From: Sue Howell <Sue.Howell@arun.gov.uk>
Sent: 26 January 2022 15:08
To: Planning.Responses <Planning.Responses@arun.gov.uk>
Cc: Amber Willard <Amber.Willard@arun.gov.uk>
Subject: Planning Consultation on: A/253/21/OUT

Application ref: A/253/21/OUT

Description: Outline planning application with all matters reserved for the erection of 1 No bungalow dwelling with off street parking and private amenity space.

Location: Land between 32 Downs Way and 2 Ambersham Crescent Angmering BN16 1AB

Indicative 3D Views

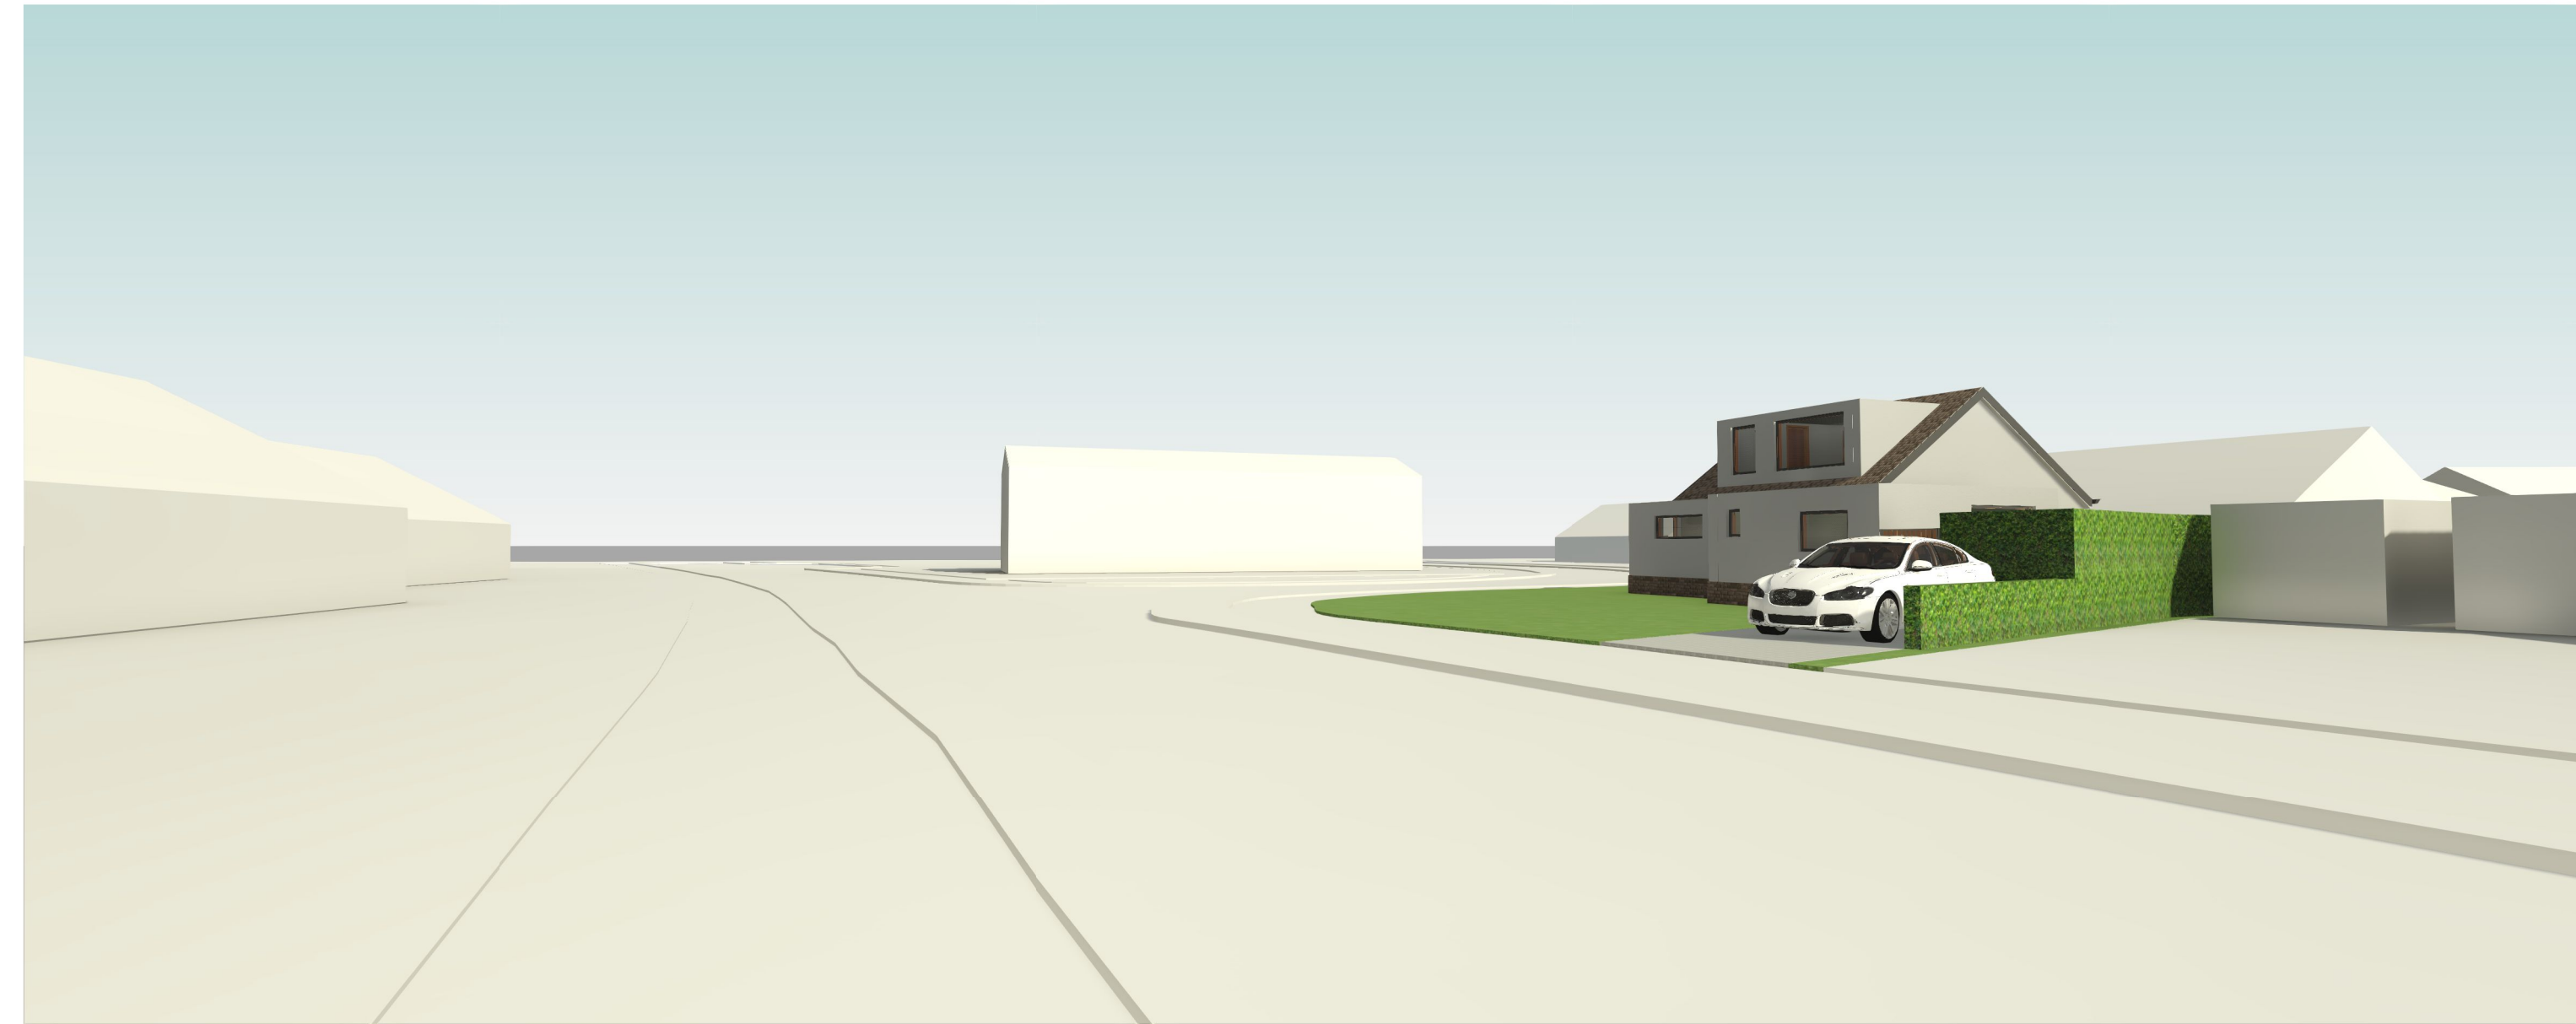
The proposals as shown would pose considerable impact on street scene in this location and would require landscaping to soften the proposals whilst maintaining an open presence in this location.

The proposals could suggest an over development of this garden plot with layout, access and resulting usable garden space. Consideration should be given to adjacent dwellings and the impact the proposals will have on street scene in this residential area

The proposals as shown, if approved, will need further landscape details to be submitted in the form of a detailed planting plan and specification detailing species choice, actual plant quantities, planting densities and size at time of planting. Detail should also be provided regarding existing trees and boundary planting including the existing trees and shrubs to be removed and retained. Planting would be required to offer screening to adjacent neighbours.
